App No: AL/21/20/OUT
Address: Land North of Lee's Yard Lidsey Road Woodgate PO20 3SU
Proposal: Outline application with some matters reserved for the erection of 38 No. dwellings consisting of 5 No. 4-bed house, 14 No. 3-bed houses & 19 No. 2-bed houses, with communal work hub & associated car parking & landscaping (resubmission following AL/57/18/OUT). This application is a Departure from the Development Plan.

Liz Annalls
Environment Officer
Environmental Protection
Chichester District Council

Tree Retention and Protection Plan

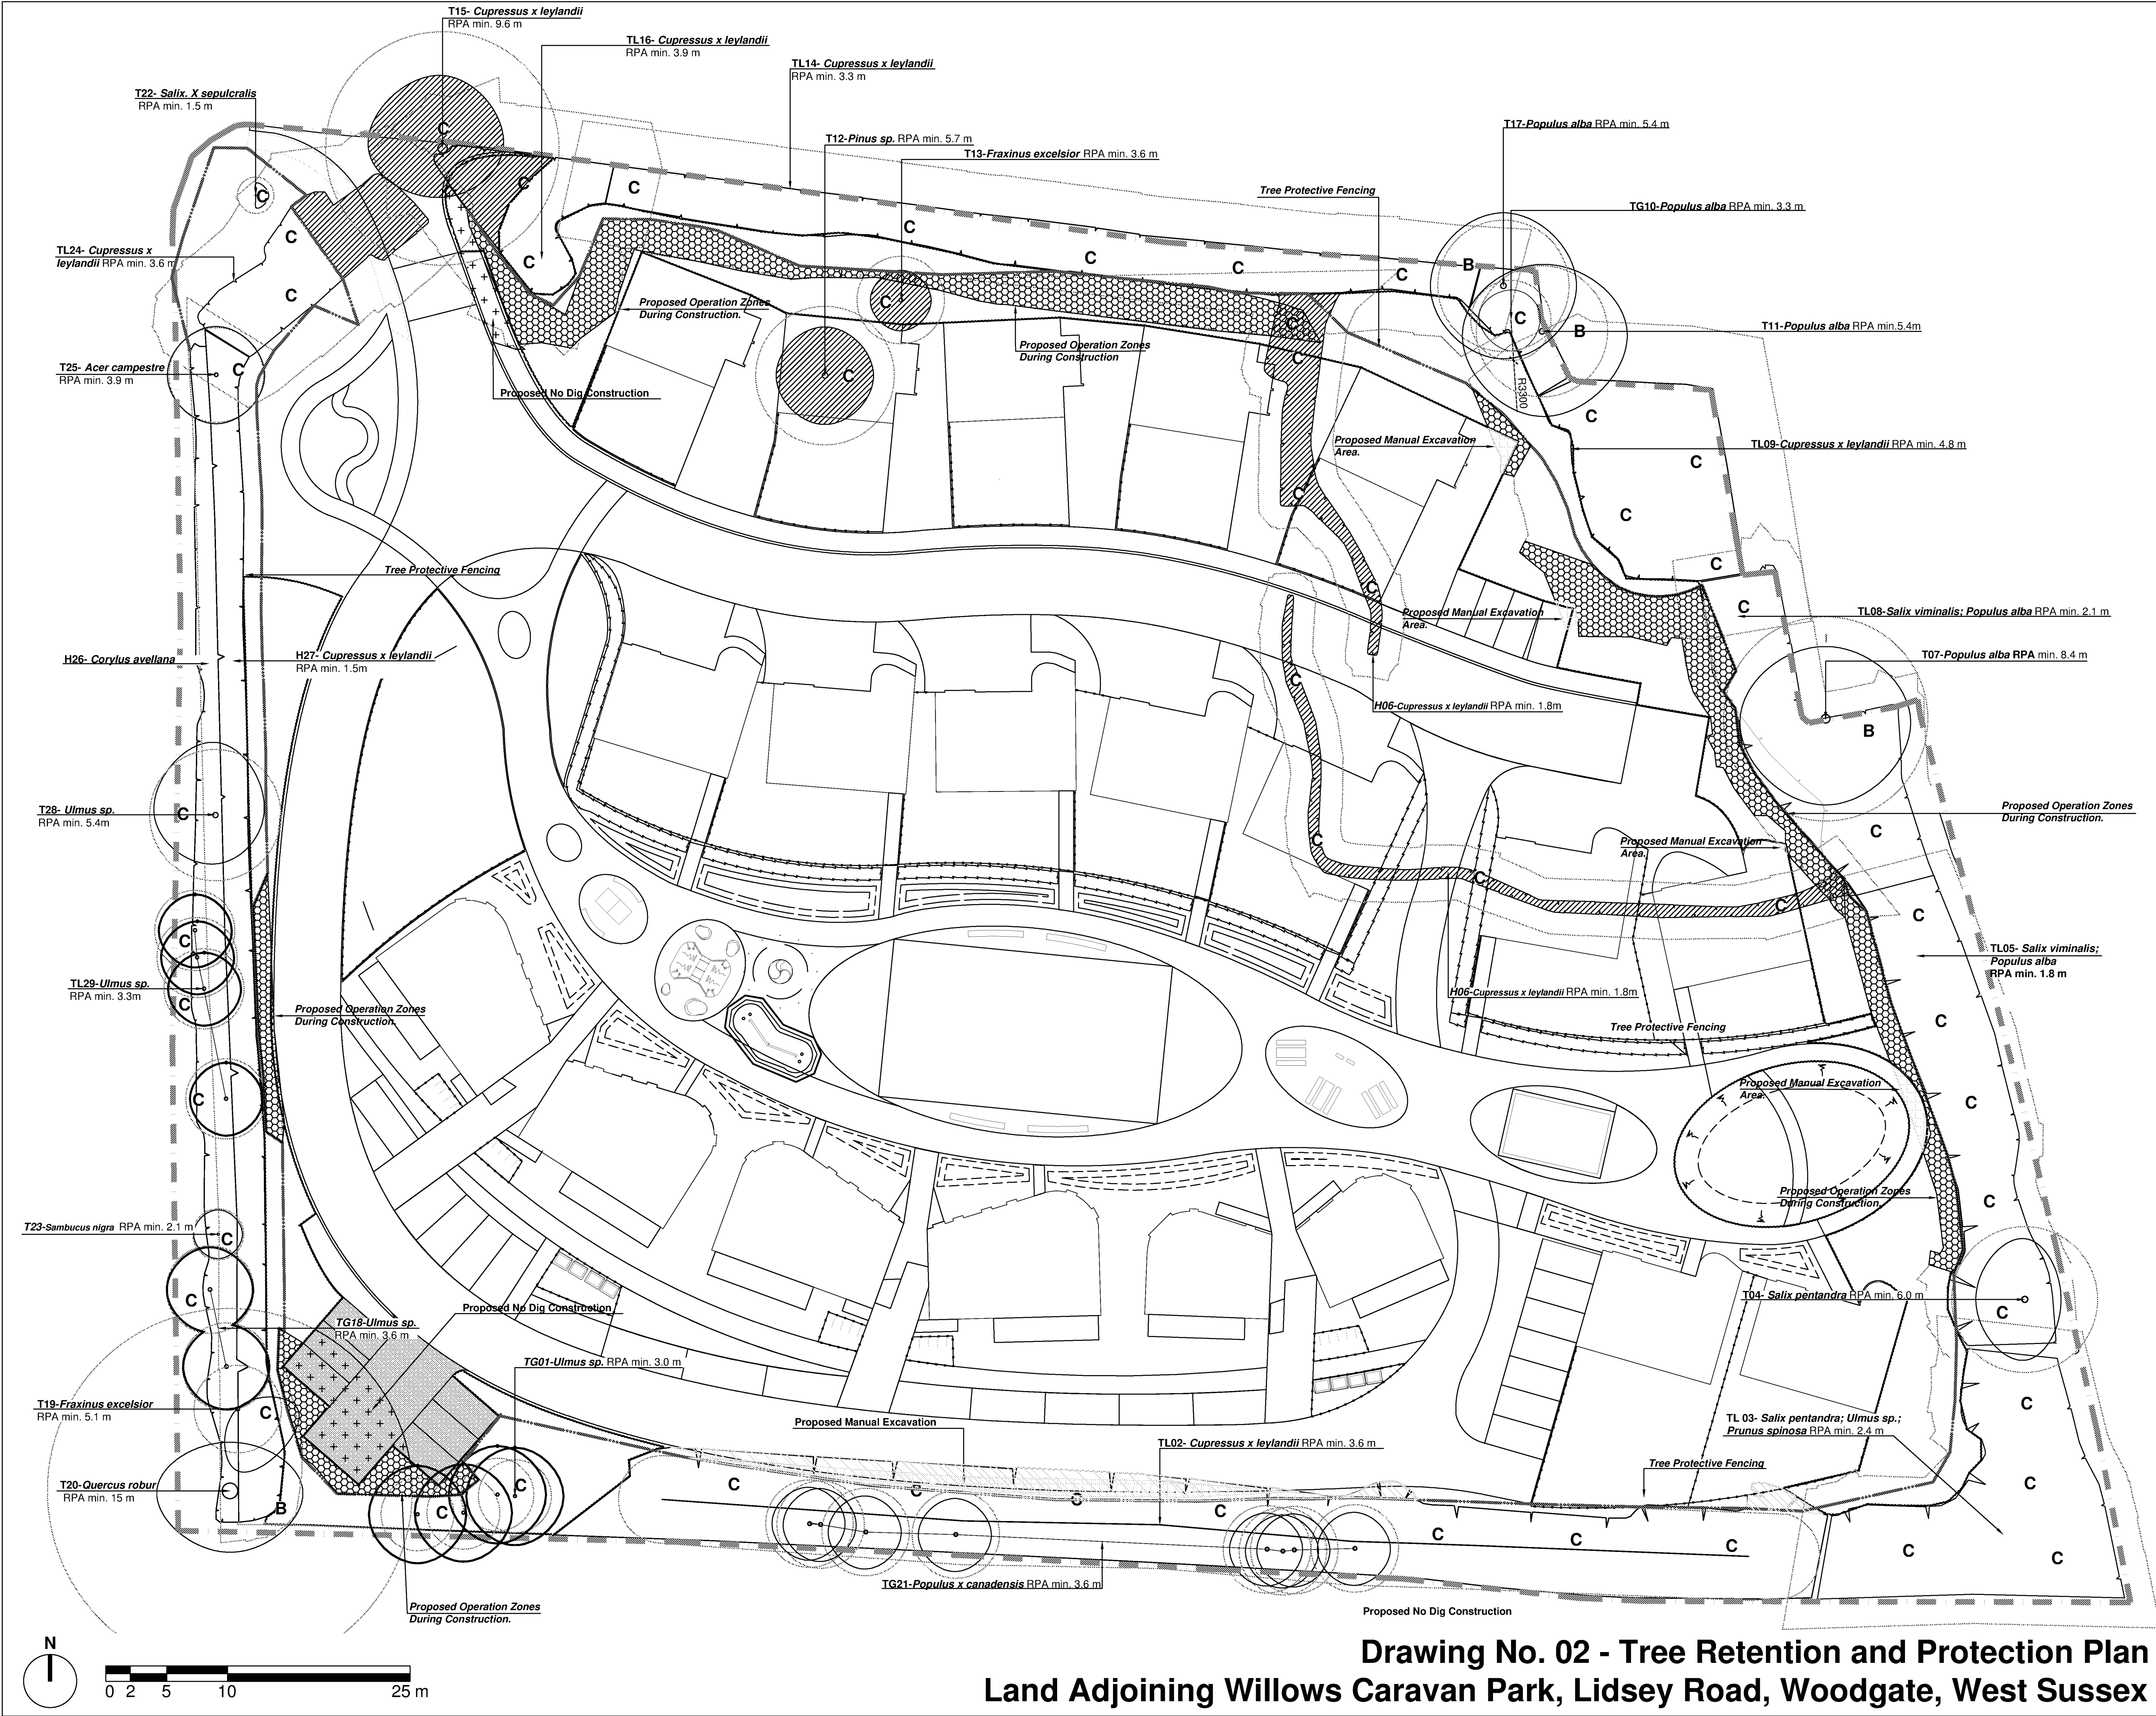
Tree T01 onsite has potential for bats, current plans show that this tree is being retained, however if this changes a bat survey may be required.
